5099
CS
United Utilities Water PLC
Developer Services & Asset Protection
Thirlmere House
Lingley Mere Business Park
Lingley Green Avenue
Great Sankey
Warrington WA5 3LP

Your ref: 3/2012/0127
Our ref: DC/12/850
Date: 13-MAR-12

Location: Dewhurst Farm, Longsight Road, Langho
Proposal: Partial construction of a farm workers dwelling and erection of 2 holiday cottages

Proposed holiday cottages at Dewhurst Farm,
Longsight Road, Langho, Blackburn, BB6 8AD~

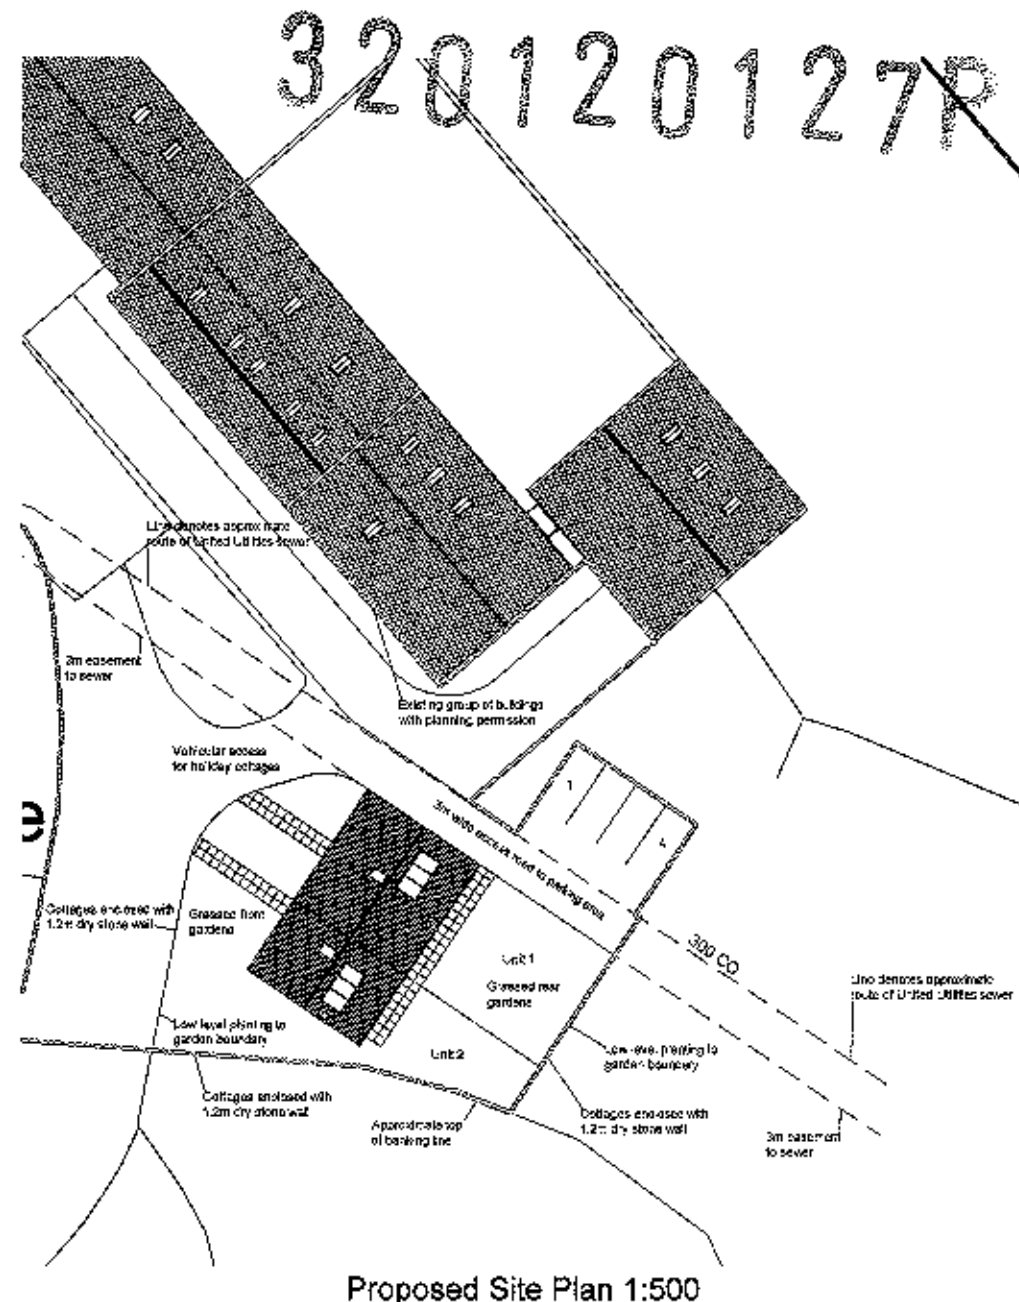
- A public sewer crosses this site and we will not permit building over it. We will require an access strip width of 6 metres, 3 metres either side of the centre line of the sewer which is in accordance with the minimum distances specified in the current issue of "Sewers for Adoption", for maintenance or replacement.

A modification of the site layout, or a diversion of the affected public sewer at the applicant's expense, may be necessary. To establish if a sewer diversion is feasible, the applicant must discuss this at an early stage with Graham Perry Developer Enquiries Analyst by email, planning.liaison@uuplc.co.uk as a lengthy lead in period may be required if a sewer diversion proves to be acceptable.
